Design Renaissance

Response Letter for Extended Family Dwelling Application

December 13, 2018

**GUEST HOUSE FLOOR PLANS**

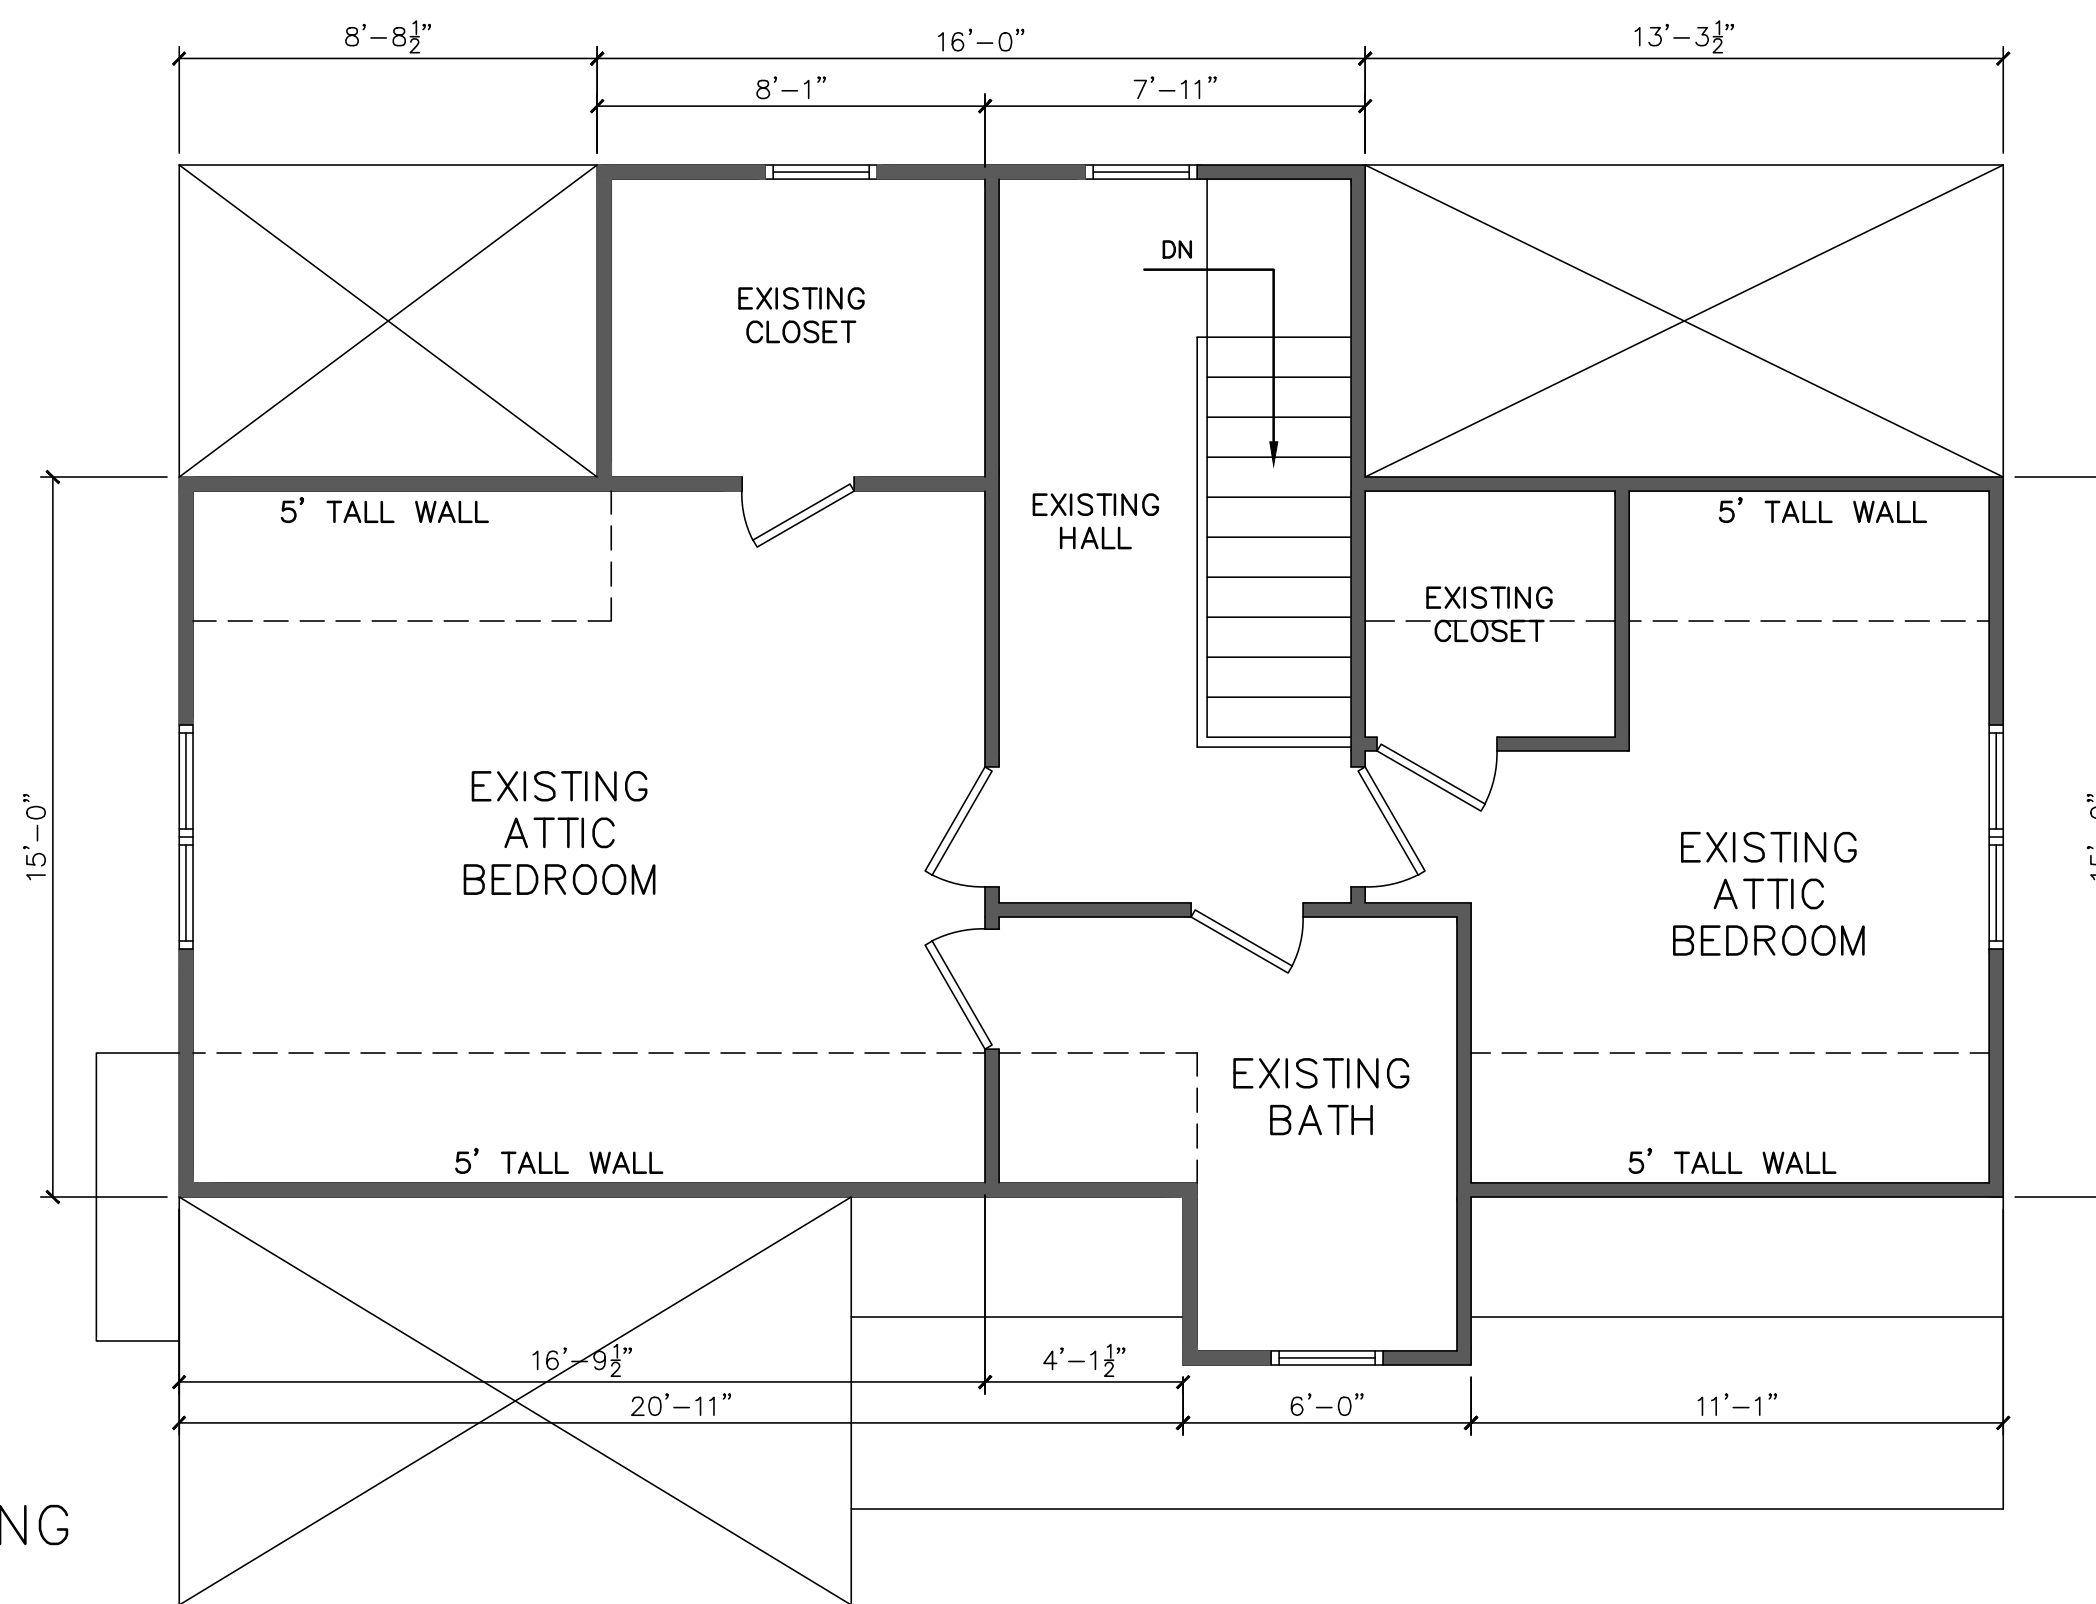
The square footage of the current house exceeds the maximum for a guest house. Address the total living area in the existing house and request that the square footage be allowed in the special use.

- Floor plan provided for entire structure. Basement area does not meet egress requirements due to non-compliant stair (tread height too high and no proper head height clearance) and non-compliant egress windows. (sill height too high and openable area too small) Basement space is used for storage, mechanical and laundry. As a correction to the Assessor's database, there are only 3 bedrooms in the house, not 4. (see floor plans)

**SITE PLAN**  
SCALE = 1:30

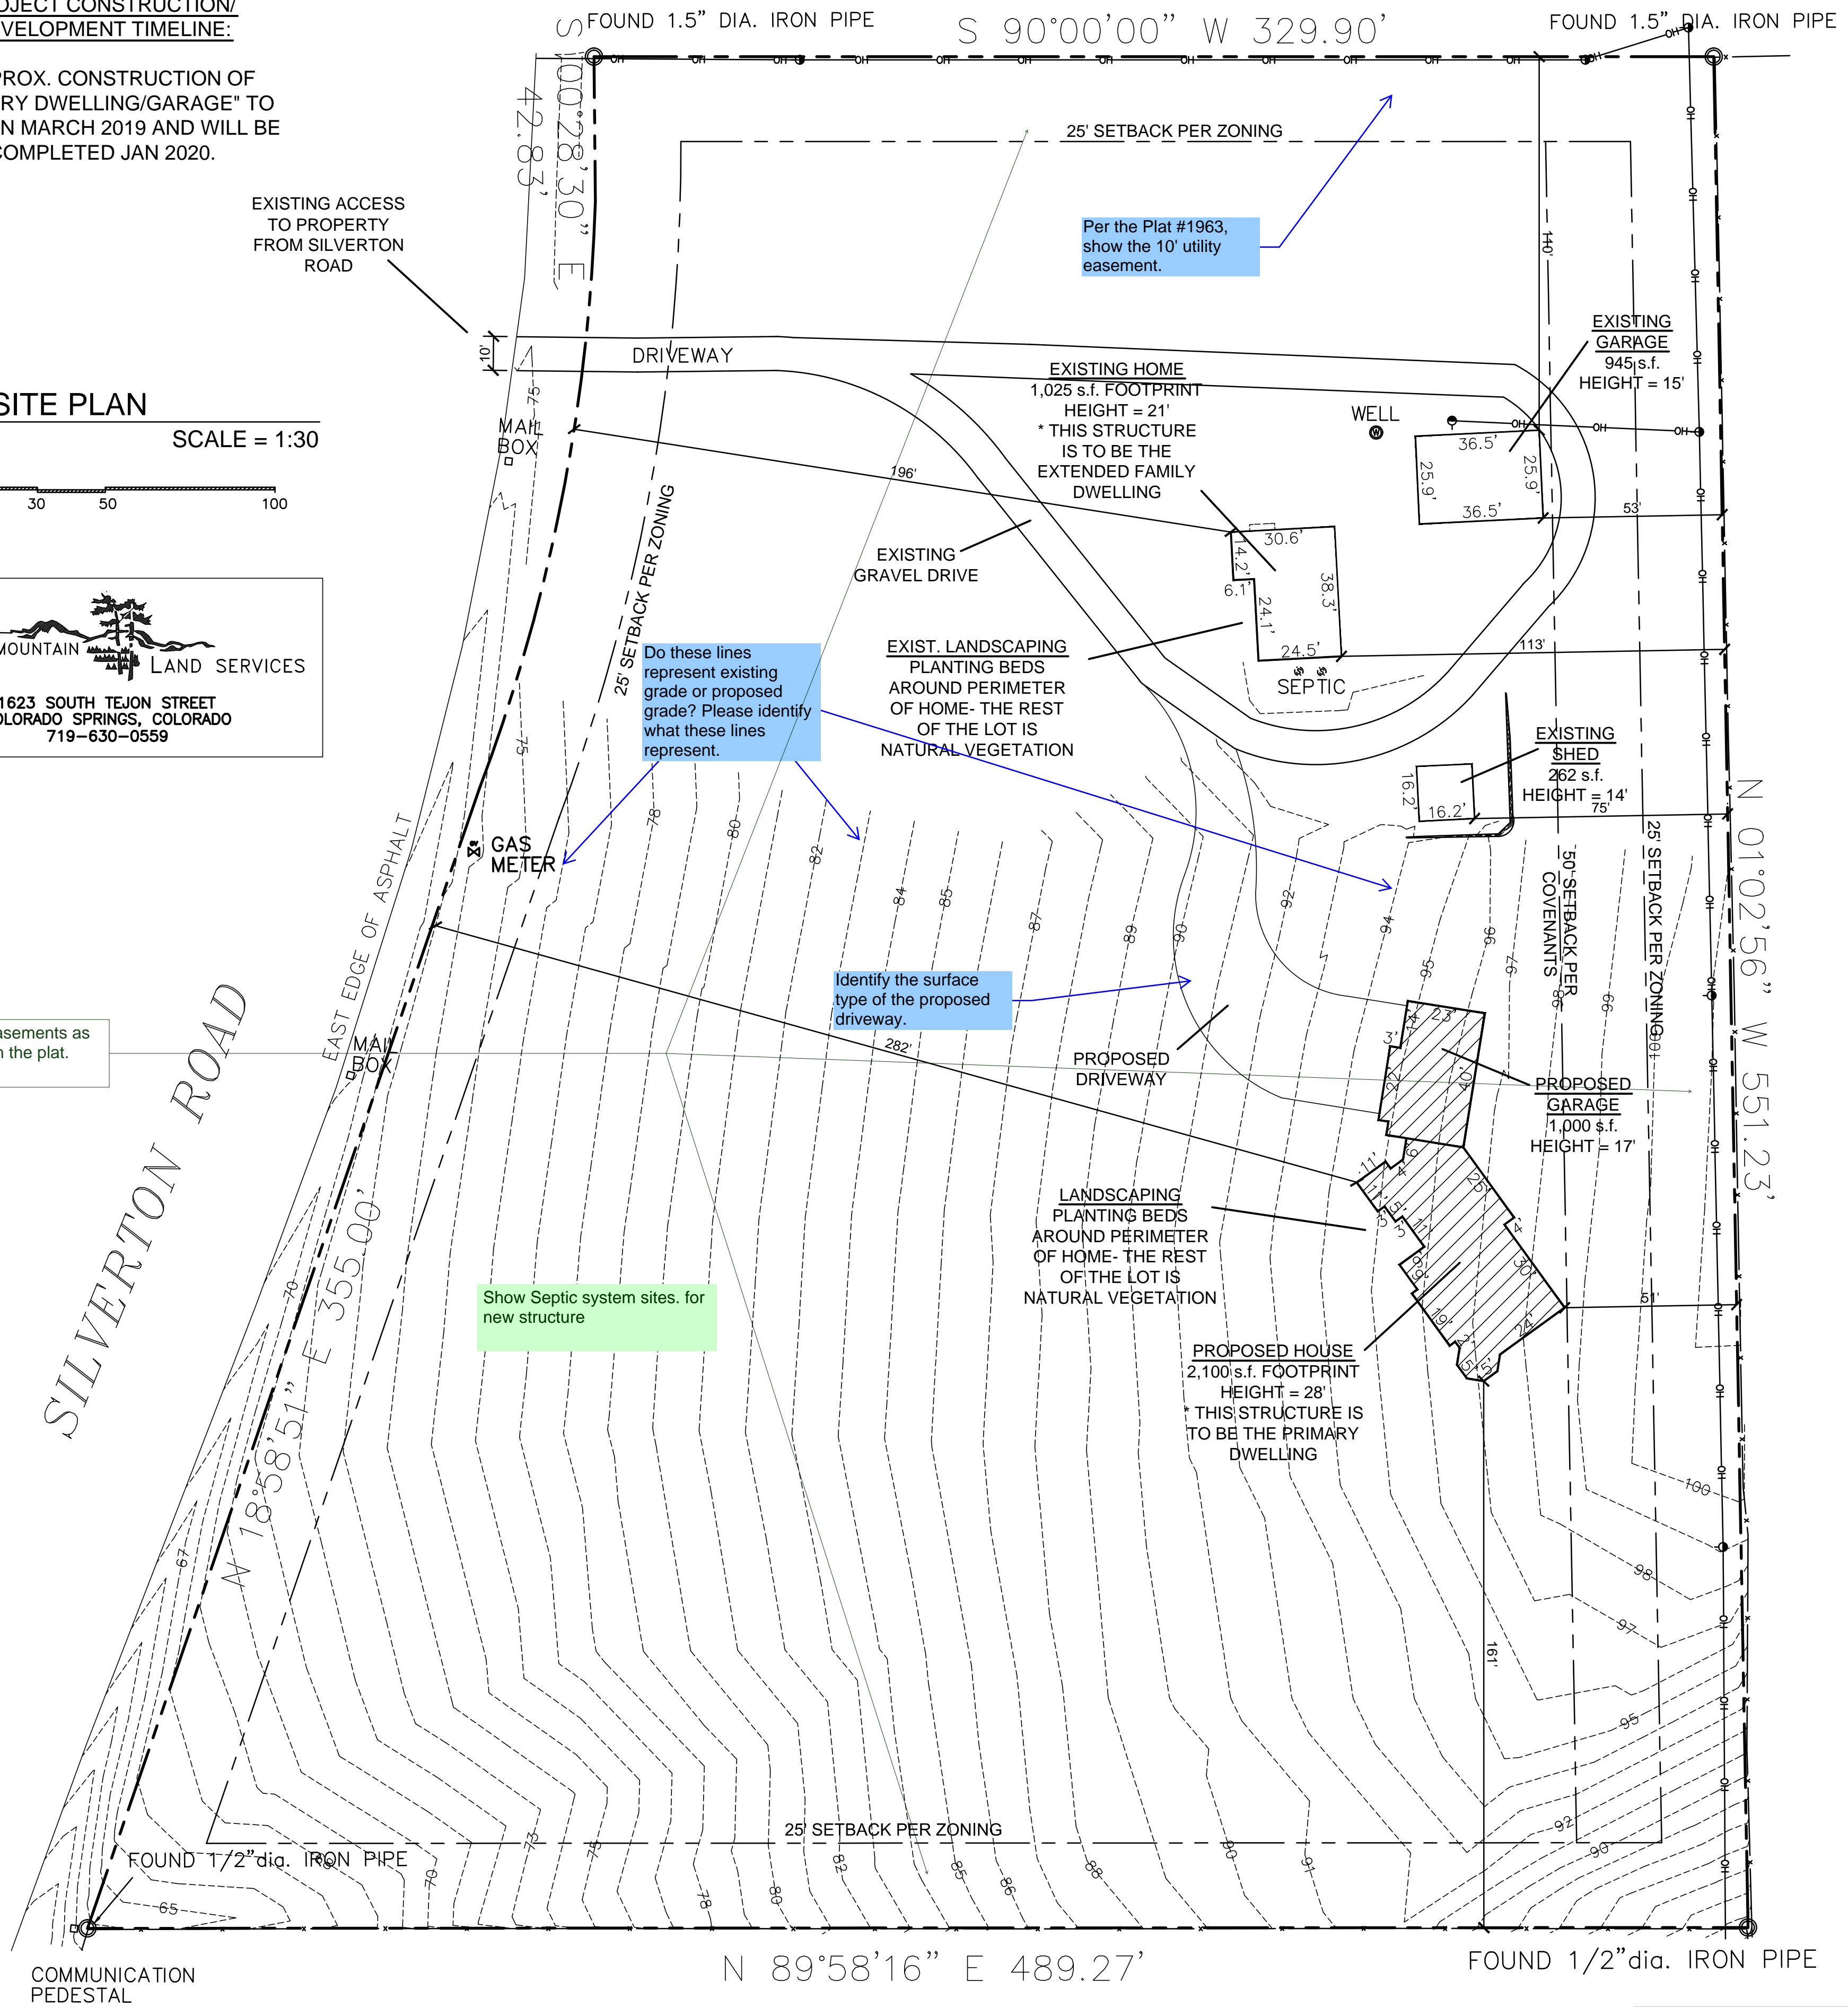
- Site Plan Comment 2: Show proposed location of future Septic and Leachfield.
 - Septic/Leach now shown. (revision cloud to identify)

- Site Plan Comment 1: Show 10' utility easement per Plat #1963.
 - This is addressed on the site plan drawing, showing easements per Plat. Surveyor identified 20' utility easements on the north and east property lines and 10' on the south line. (revision clouds to identify)

- Site Plan Comment 2: Clarify the topography lines shown on the site plan.
 - The topography lines shown are "existing contours" shown be bring context for the basic contour of the lot. A final grading plan will be completed once the proposed structure is designed and will be submitted to the building department for review. A note has also been added to the site plan stating that final drainage patterns will not adversely affect neighboring properties. (revision cloud to identify)

- Site Plan Comment 3: Identify the surface type of the proposed driveway.
 - Proposed driveway will be Gravel with concrete "apron" in front of garage doors. (revision clouds to identify)

- Site Plan Comment 4: Add PCD File No. AL 1825
 - File No. added to lower right corner of site plan. (revision cloud to identify)
- Letter of Intent Comment 1: State that existing driveway access will be used for Proposed structure and that a Driveway Permit will be obtained.

- Site Plan Comment 1: Existing well to serve both existing and proposed houses.
 - This is addressed with a note on the site plan drawing. (revision cloud to identify)
- Site Plan Comments 2 and 3: Existing wastewater service for the existing house only to be used for existing house. And a new OWTS Permit and Service is required for the Proposed House.
 - This is addressed with a note on the site plan drawings. (revision cloud to identify)

- Site Plan Comments: Contact MVEA for line extension policy. And any removal or extension of facilities on this property will be at the expense of the applicant.
 - This is addressed with a note on the site plan drawing. (revision cloud to identify)
